Address: 10 Broomhouse Close Huddersfield HD8 8UX

Application number: 2024/44/93025/E	
What is the application for?:	Discharge of details reserved by conditions 10 (cycle parking), 11 (EV charging)
Address of the site or building:	Land adj, Inkerman Court, Barnsley Road, Denby Dale, Huddersfield, HD8 8XA
Postcode:	HD5 0AL

ANSI/IES TM-30-18 Color Rendition Report

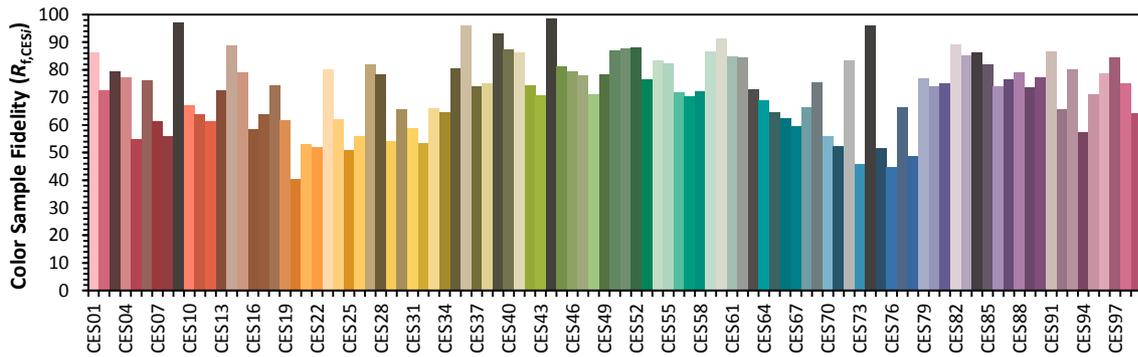
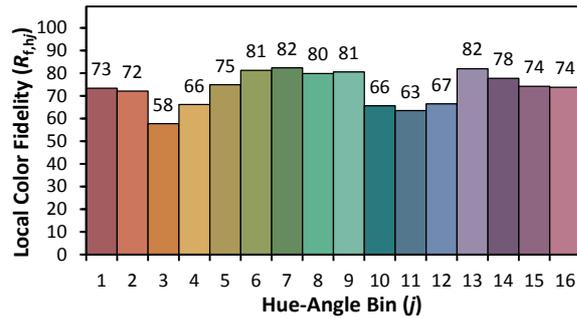
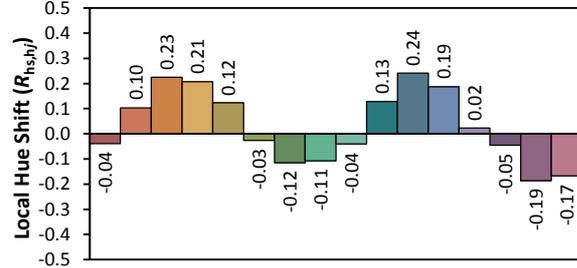
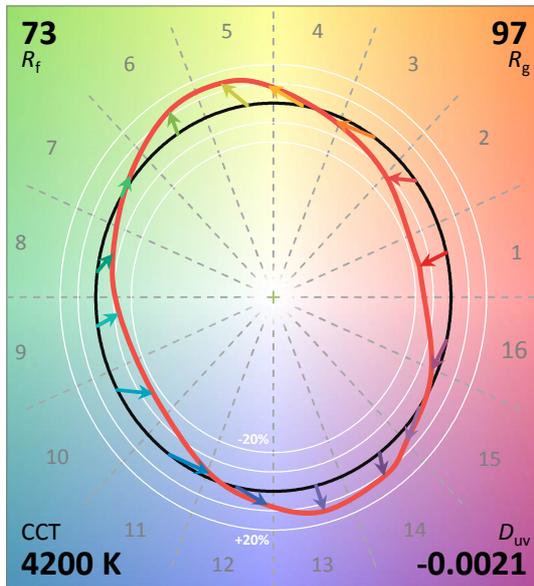
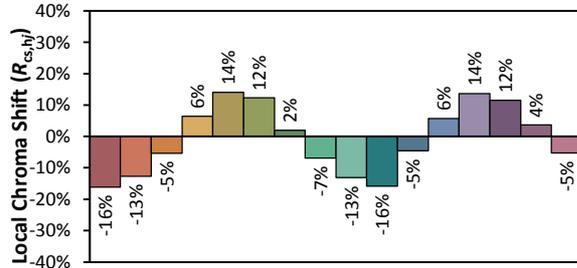
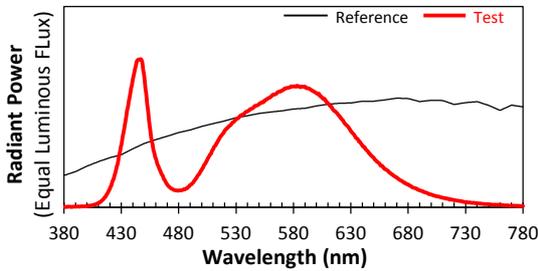
Type of comment: An objection	
Do you wish your comments to be published on the website anonymously?	No
<p>The application includes a stand alone colour chart, which is an American Standard ANSI, there is no cross reference in the other documents tying in this standard & referring to the appropriate England / EU standard</p> <p>.</p> <p>The plan shows a bleeding of the light onto the main A635 highway.</p> <p>.</p> <p>This comment is made because there is a considerable failure of street lighting LED bulbs, many of these lights are turning blue and causing invisibility spots...</p> <p>.</p> <p>It is important for Kirklees to ensure that the developer is fully liable and responsible for the full maintenance period prior to highway adoption of these lights</p>
